DRB Application No.: 09DRB-70289 Project # 1007054
 Project Name: HEIGHTS RESERVOIR ADDITION
 Agent: WAYJOHN SURVEYING Phone No.:

RE: Lots 15 – 19, Block 31, Heights Reservoir Addition

RE: Minor Preliminary/Final Plat of Lots 16-A through 19-A, Block 31, Heights Reservoir
Addition, Project No. 1007054

PLAT OF
LOTS 16-A, 17-A, 18-A & 19-A
BLOCK 31, HEIGHTS
RESERVOIR ADDITION

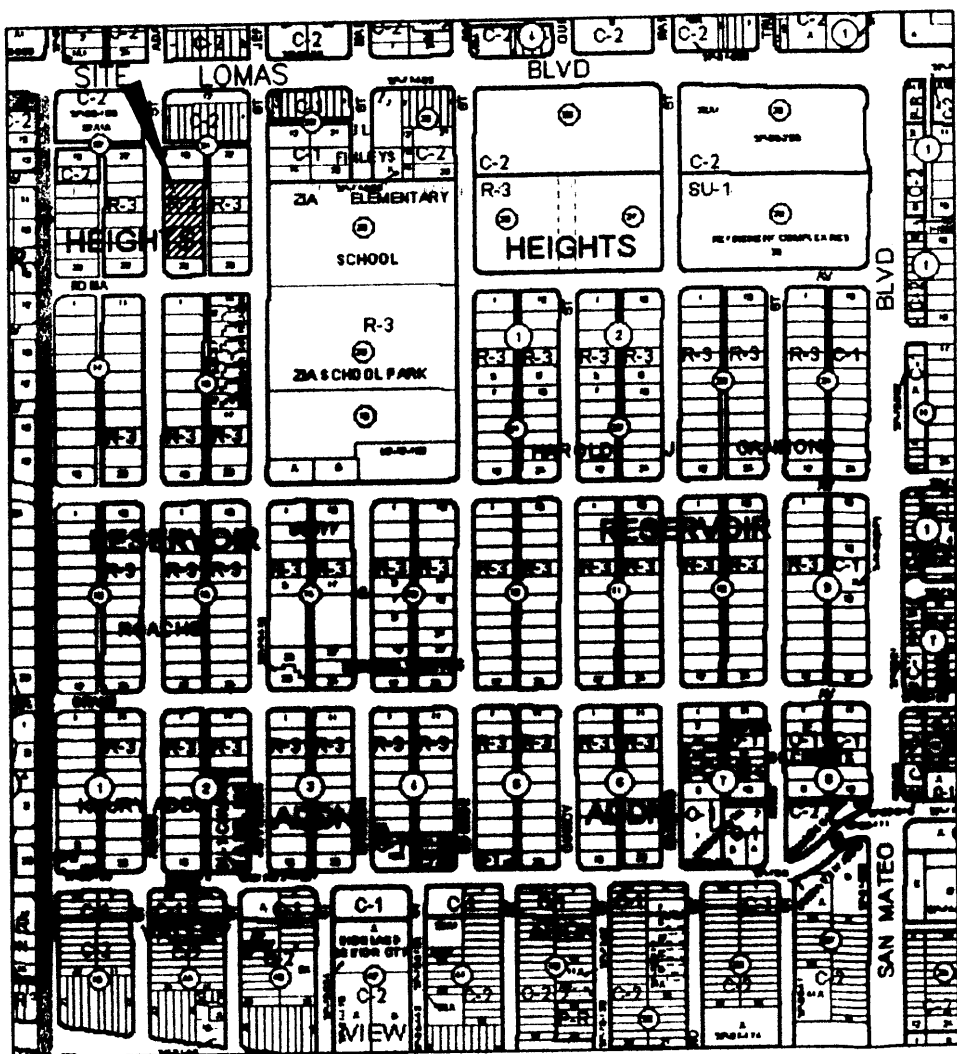
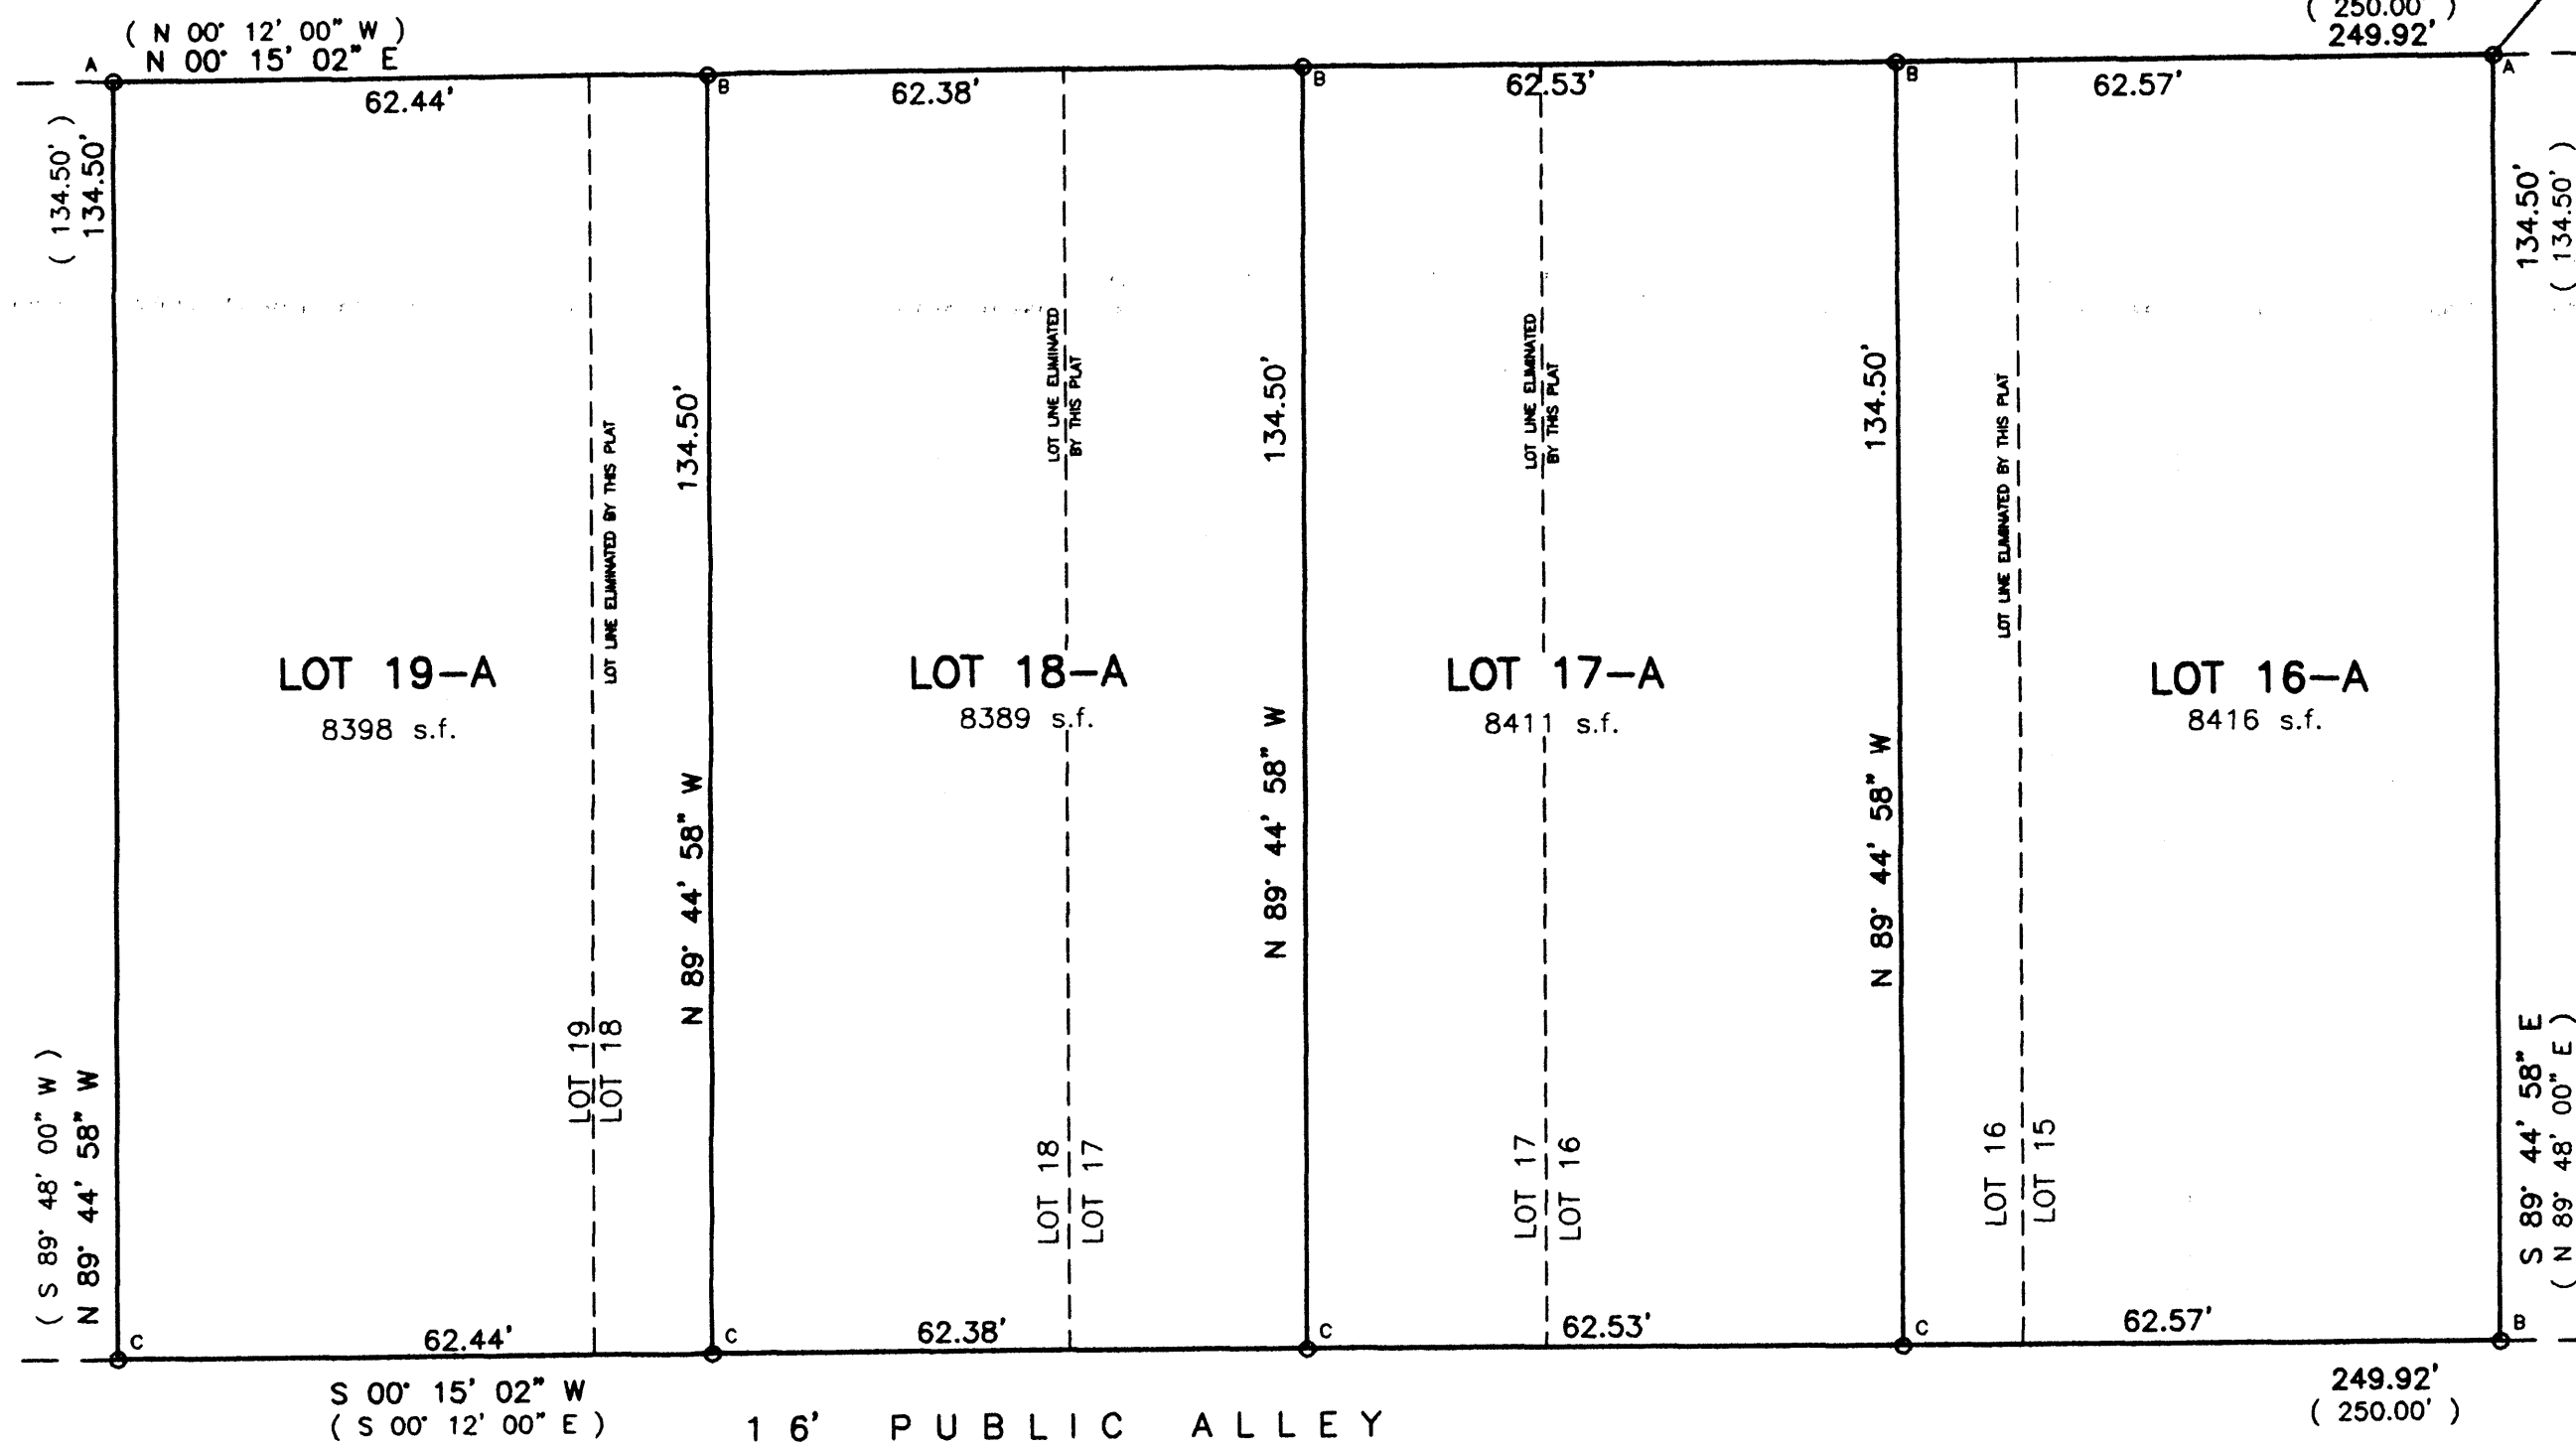
For future reference, please remove Zoning Note (No. 3) from final plats.
